From: Anita Gardner
Sent: 01 May 2019 17:31
To: Planning.Responses
Subject: FW: CM/4/19/PL - Crematorium - Land South of A259 Grevatts Lane, Climping
Attachments: SC-CLMPG-V1-XX-DR-K-0500 SITE PLAN REV F.pdf; BWREDE17 Grevatt's Lane Climping - Summary of Site Access Assessment.pdf

From: Stephen Gee [redacted]
Sent: 30 April 2019 14:17
To: Anita Gardner
Subject: RE: CM/4/19/PL - Crematorium - Land South of A259 Grevatts Lane, Climping

Anita,
Thanks for forwarding on, I'll take a proper look at this tomorrow but at first glance an exception report is likely to be required over the speed limit issue and further design work required if the gates are on existing highway land.

| DRAWING NO:  | SC-CLMPG-V1-XX-DR-K-0500 | REVISION: | F        |

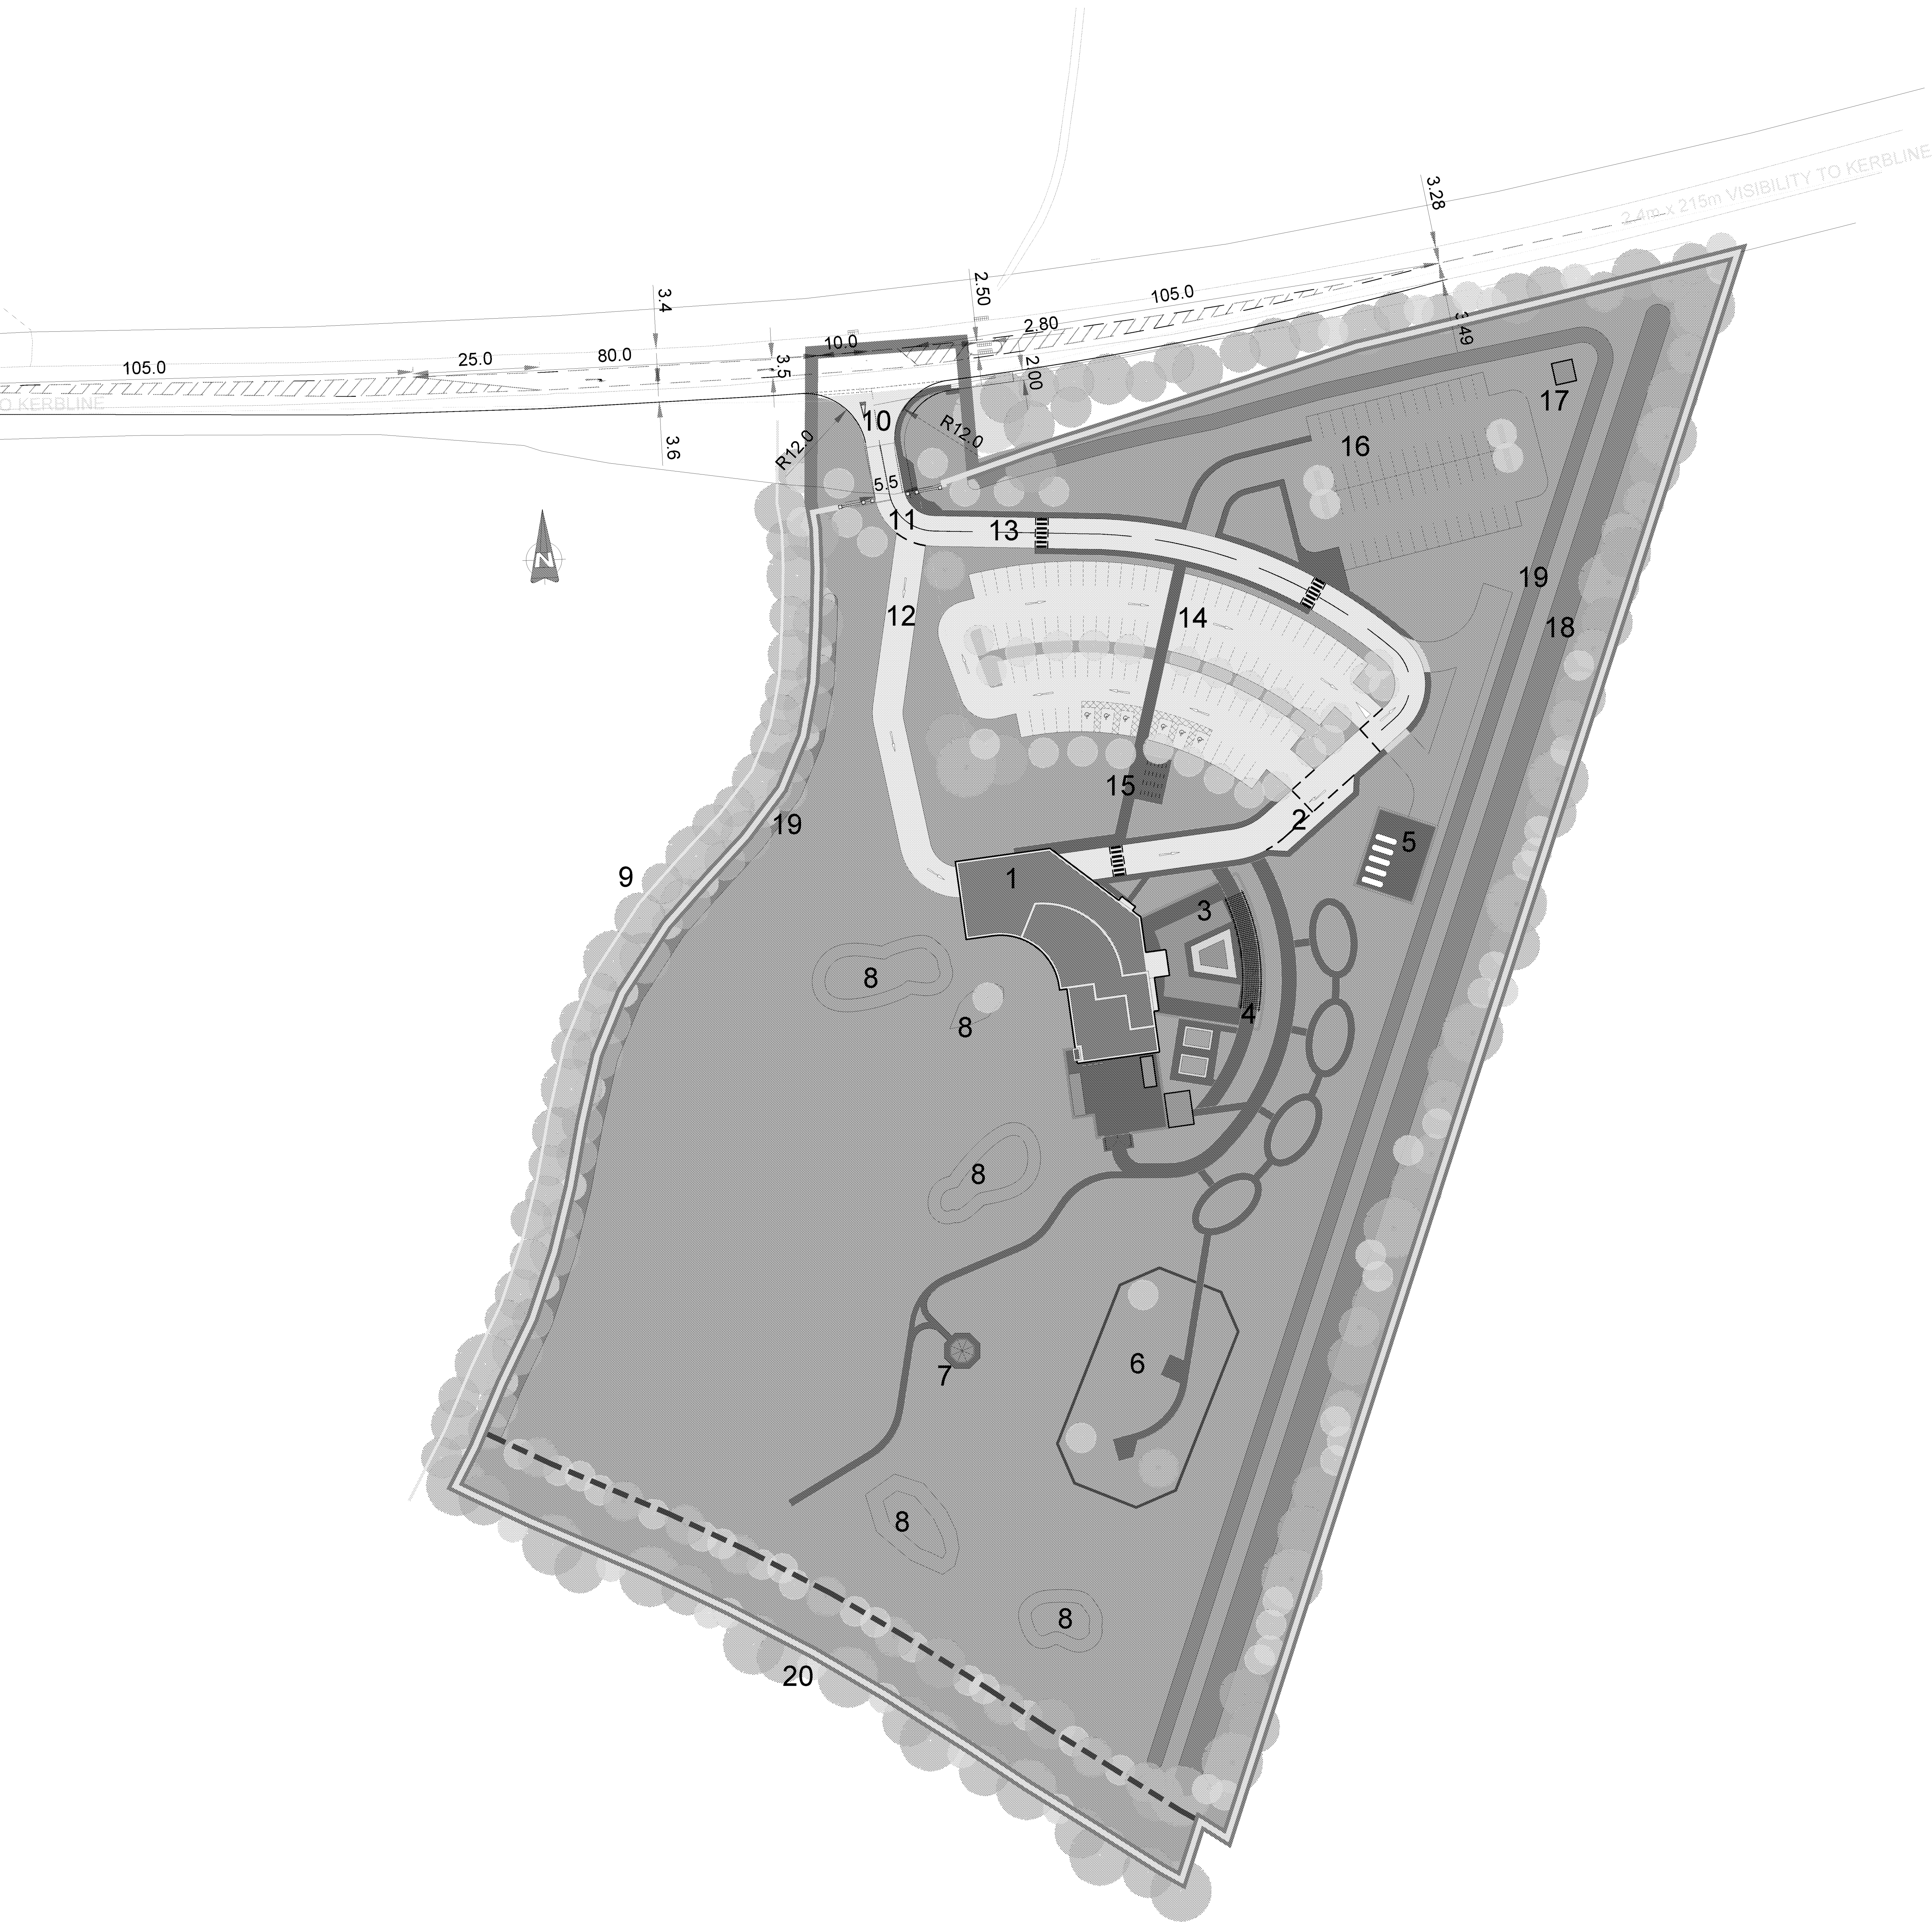
One element of information requested and yet to be provided is junction modelling of the site access. Are you able to remind the applicant of this request.

Please see the attached Site Access Assessment in response to your colleague's comments. We have also updated the site plan, relocating the entrance gates slightly to ensure that they are not on highways land, and a copy of that is also attached.
